Application number: 2023/92266	
What is the application for?:	Demolition of part of boundary wall to create entrance for off street parking (w
Address of the site or building:	50, Birkby Lodge Road, Birkby, Huddersfield, HD2 2BG
Postcode:	HD2 2BG

Type of comment: An objection	
Do you wish your comments to be published on the website anonymously?	No

| REV     | DESCRIPTION                                   | DATE | DRAWN   |
|---------|-----------------------------------------------|------|---------|
| DRAWING | Site Layout                                   |      |         |

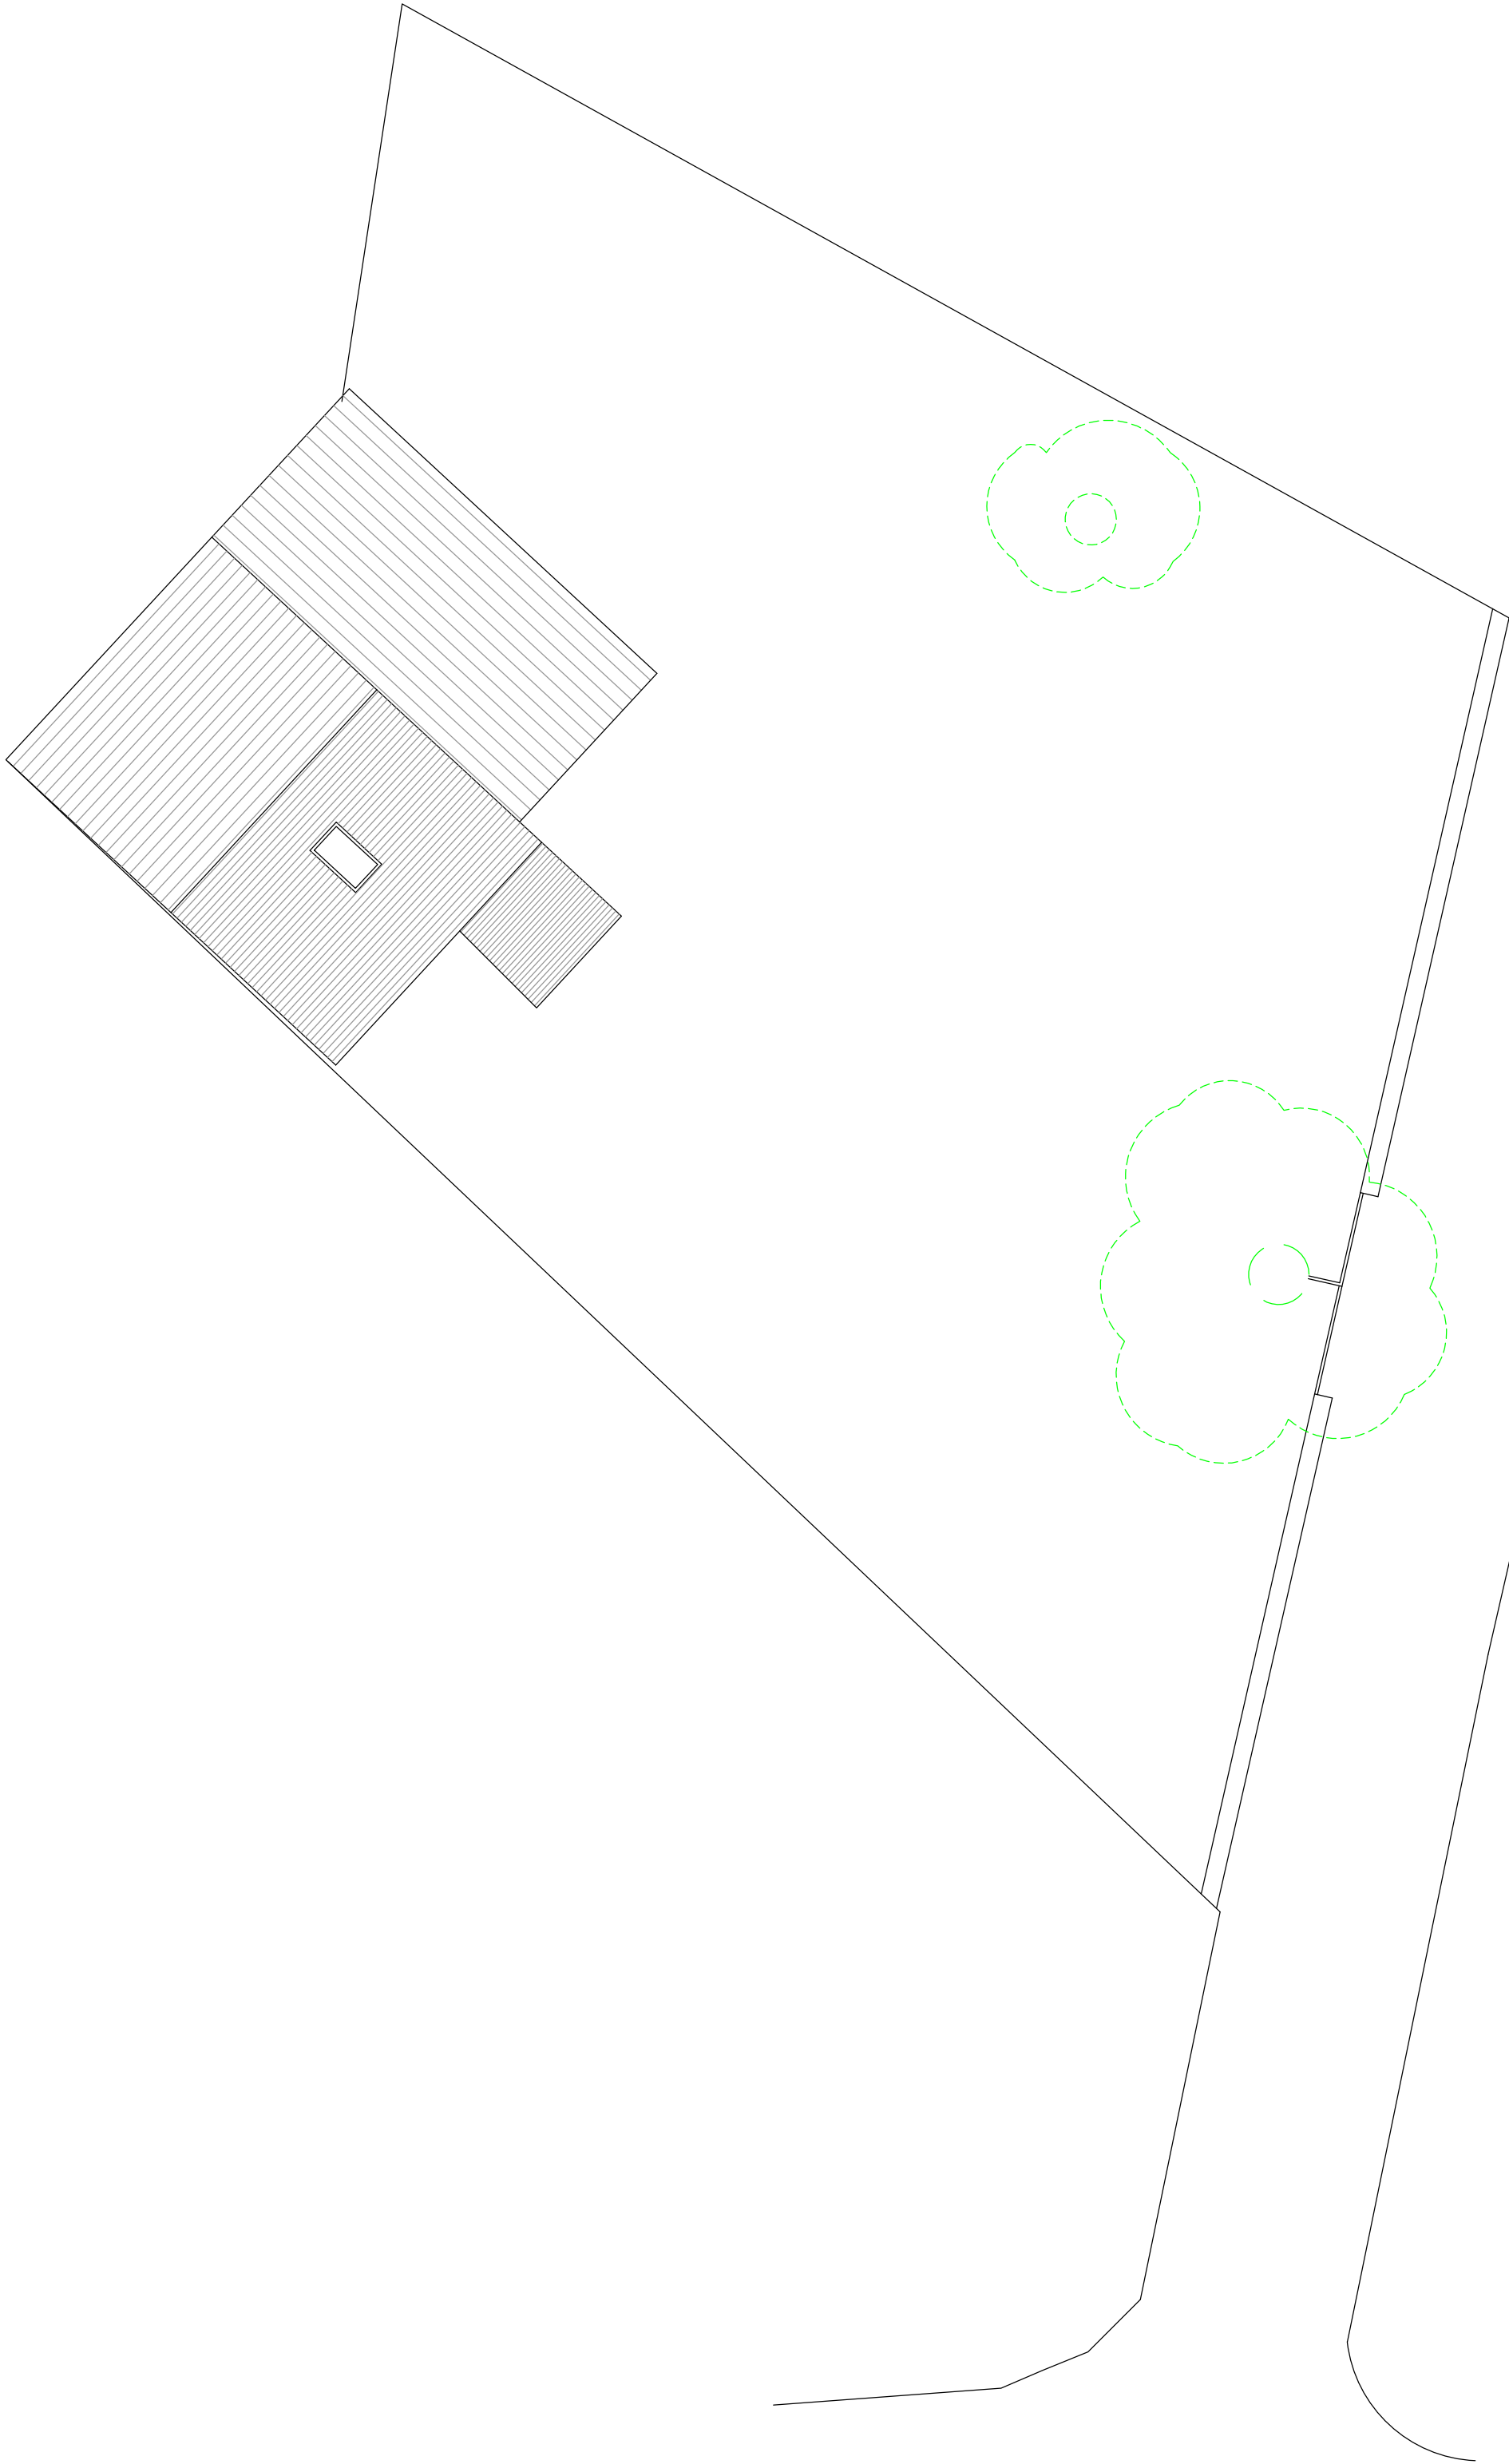
I object strongly to this application firstly and predominantly on the grounds of highway and public safety. It is misleading that this is merely a matter of a boundary wall being demolished. The access to the garden of number 50 which the plans suggest is along a very well used public footpath, the entrance and exit from which is via a narrow and characterful old stone gateway and onto a part of the road just below a very dangerous bend and right next to a bus stop. I was surprised the highways officer last time this was raised did not object, perhaps because they had not been to the area and seen the situation with the cars and buses sometimes coming fast down the hill and around the sharp bend and the parked cars to the other side causing awkward meeting and passing situations. As a volunteer at the wildlife garden adjoining the property I have seen one or two cars attempt to temporarily back into end of the footpath next to the electricity sub station, when delivering wood chips etc. and the narrowness and the angle, along with people passing on foot, made this very tricky. The footpath links with two other footpaths, linking 3 parts of Birkby and providing the main access to the wildlife garden. Many children use the path to access the 3 (or even 4) nearby primary schools, particularly St Patrick's and Birkby Infant and Nursery School. I myself used it as a route to school when my children were younger. Also the route is well used by dog walkers and others.

My other objections are on the grounds of damage to trees and wildlife, and to the character of the conservation area. The trees in the garden have already suffered from the clearing of the garden. Building a driveway and having cars driving over the footpath seems to me bound to have a bad effect on the vegetation and wildlife. Much of the old dry stone wall around the garden has collapsed due to the excavation work. The wall nearer the road and near to the listed Birkby Lodge needs to be retained and I think must be quite a lot higher than the metre which I am given to understand is the height at which permission needs to be sought.

The 2 cottages of which 50 is one appear on a map dated about 1790 and are among the oldest buildings in Birkby. While I can understand the new residents wanting extensions I think the view of the site from the road, the angles of the houses and the old stone walls are part of the local scenery we need to protect.
